From: Sarah Burrow <Sarah.Burrow@arun.gov.uk>
Sent: 12 July 2022 11:31
To: Planning.Responses <Planning.Responses@arun.gov.uk>
Cc: Maria Tomalova <Maria.Tomalova@arun.gov.uk>
Subject: RE: Planning Consultation on: BN/65/22/PL

Engineers Comments Regarding Surface Water Drainage

Application No: BN/65/22/PL
Registered: 7th June 2022
Site Address: Land at rear of Cedar End Eastergate Lane Eastergate PO20 3SJ
Grid Reference: 494923 106106
Description of Works: Sever land and erection of 1 No bungalow with new vehicular access (resubmission of BN/14/22/PL). This application is a Departure from the Development Plan and is in CIL Zone 3 and is CIL Liable as new dwelling.

Proposed Site Plan
1:200

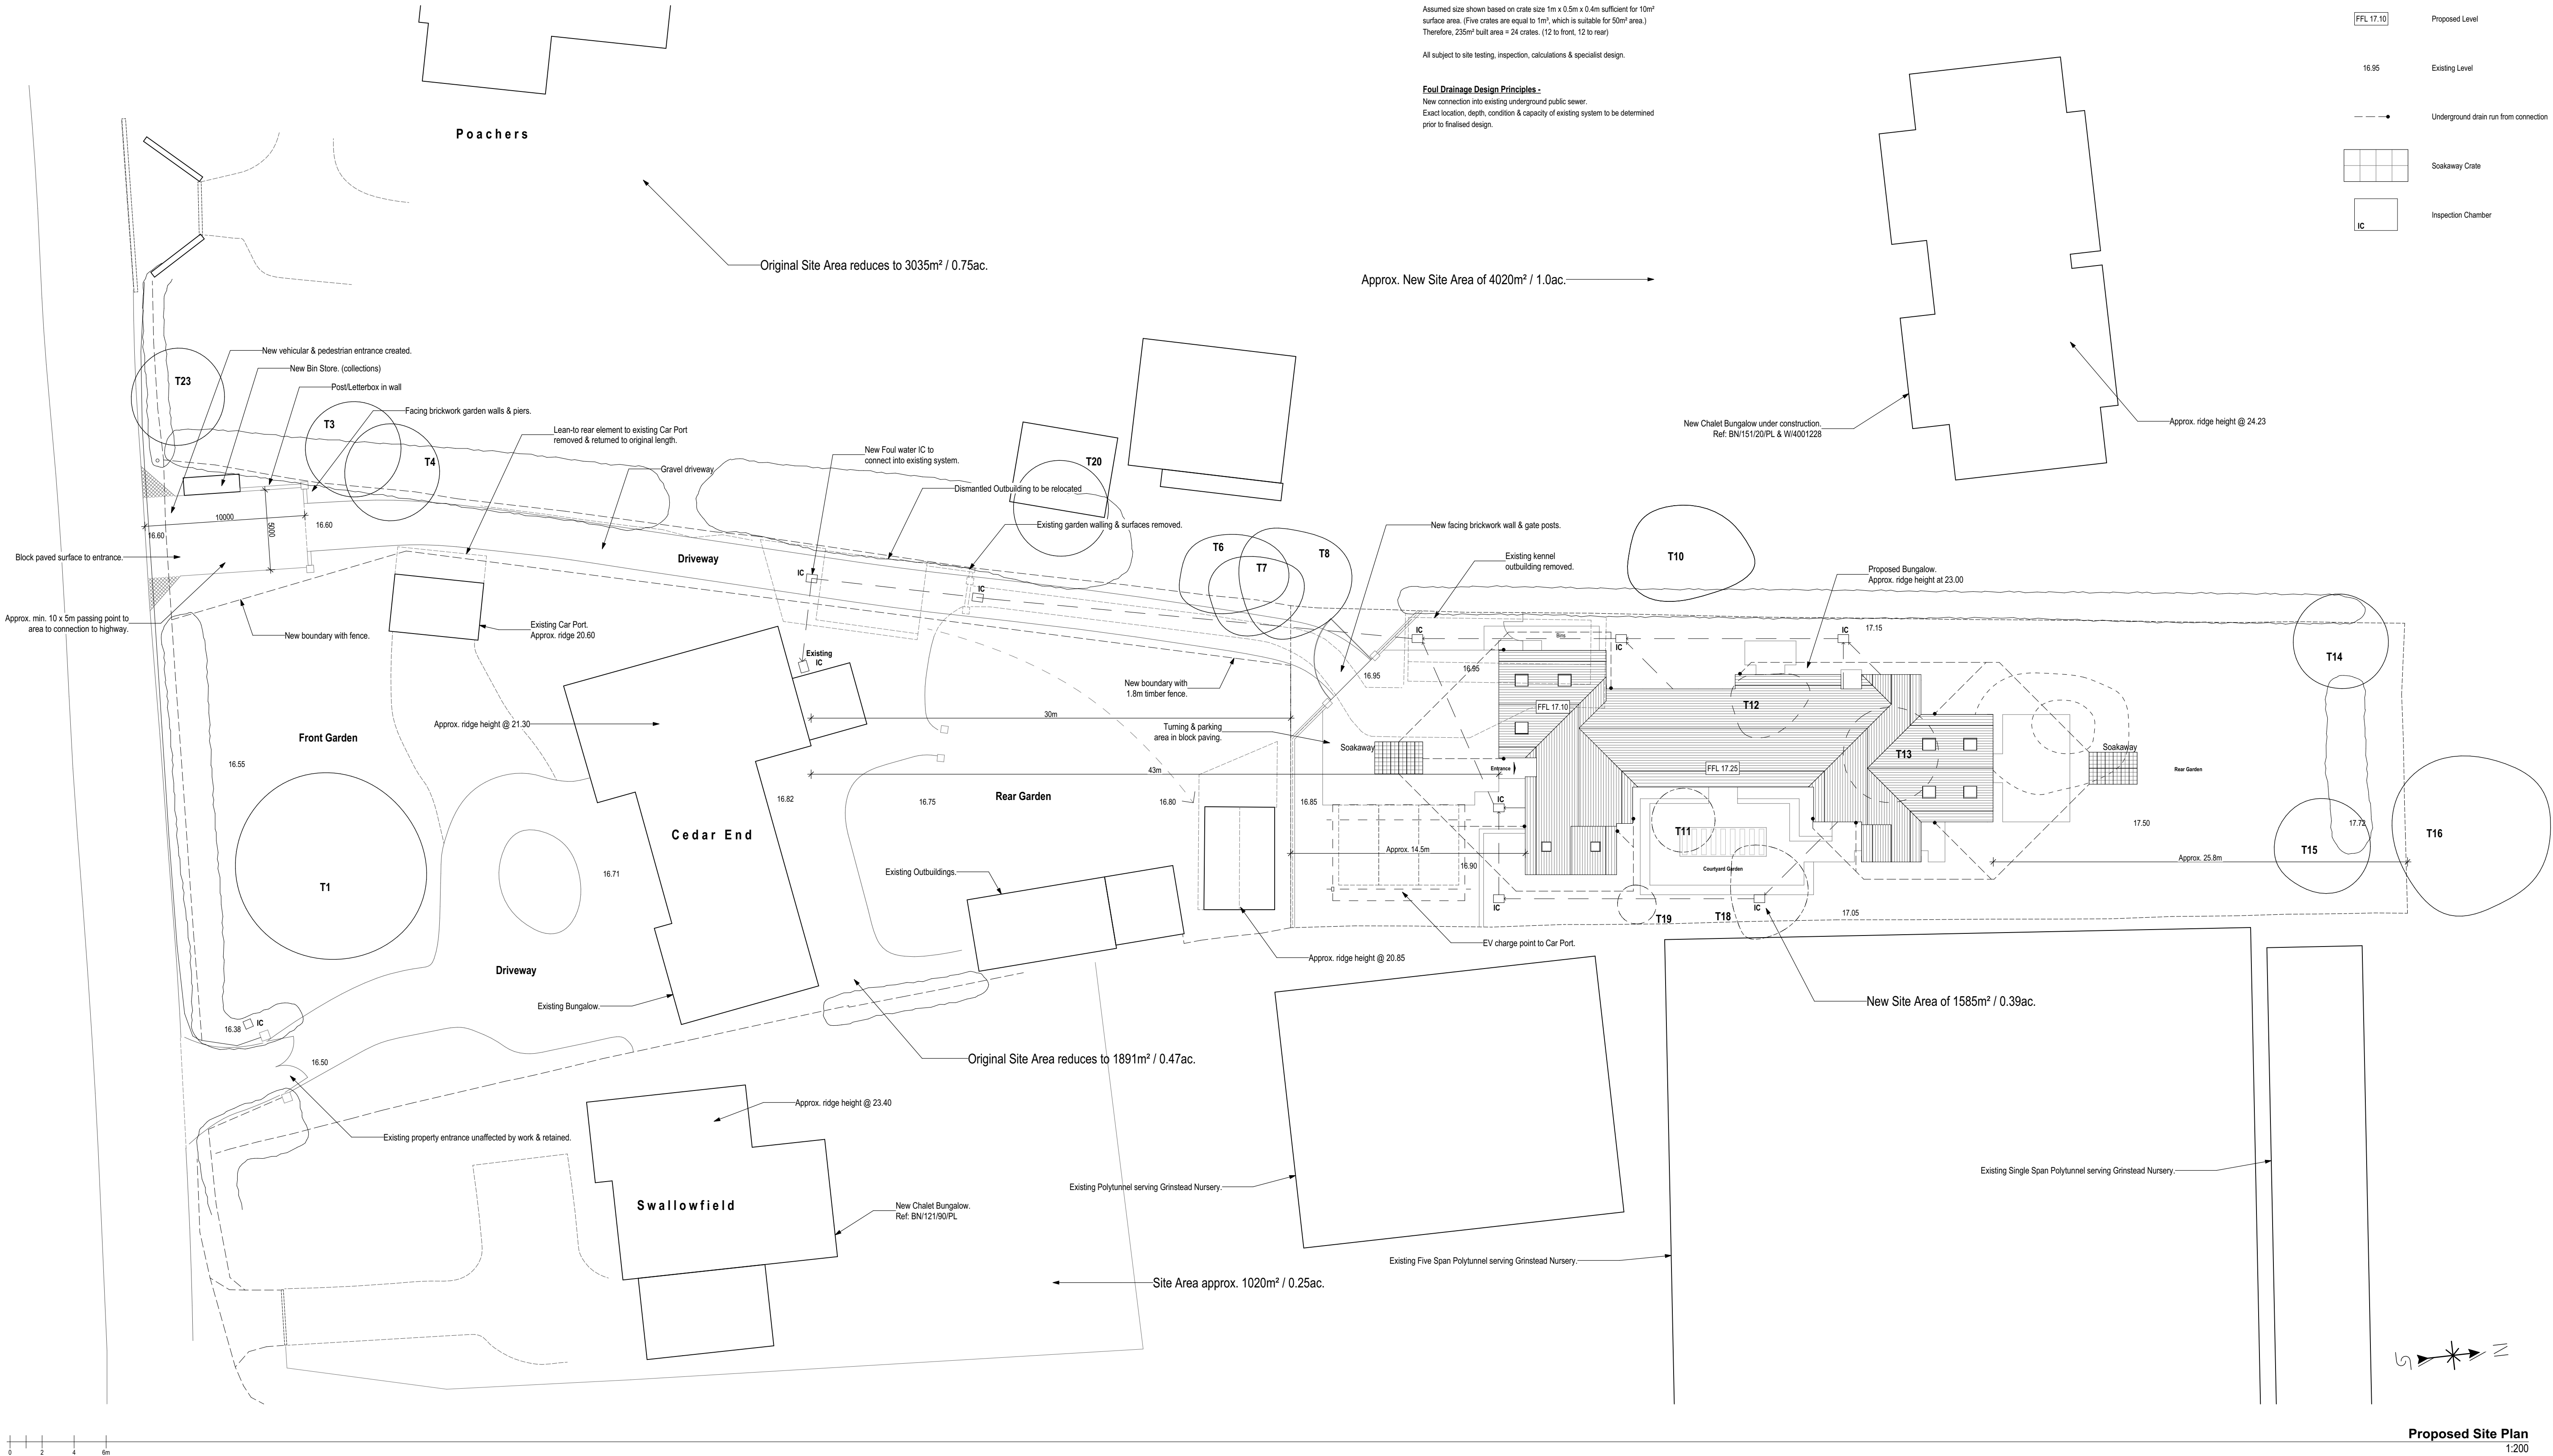
The application is within the Lidsey Treatment Catchment, therefore surface water drainage design should be carefully considered. Infiltration must be fully investigated. The site is also within a groundwater protection zone and therefore the EA will need to be consulted on any proposals to infiltrate surface water to ground.

Existing and proposed trees (root protection zones) must not conflict with suds features/pipework.
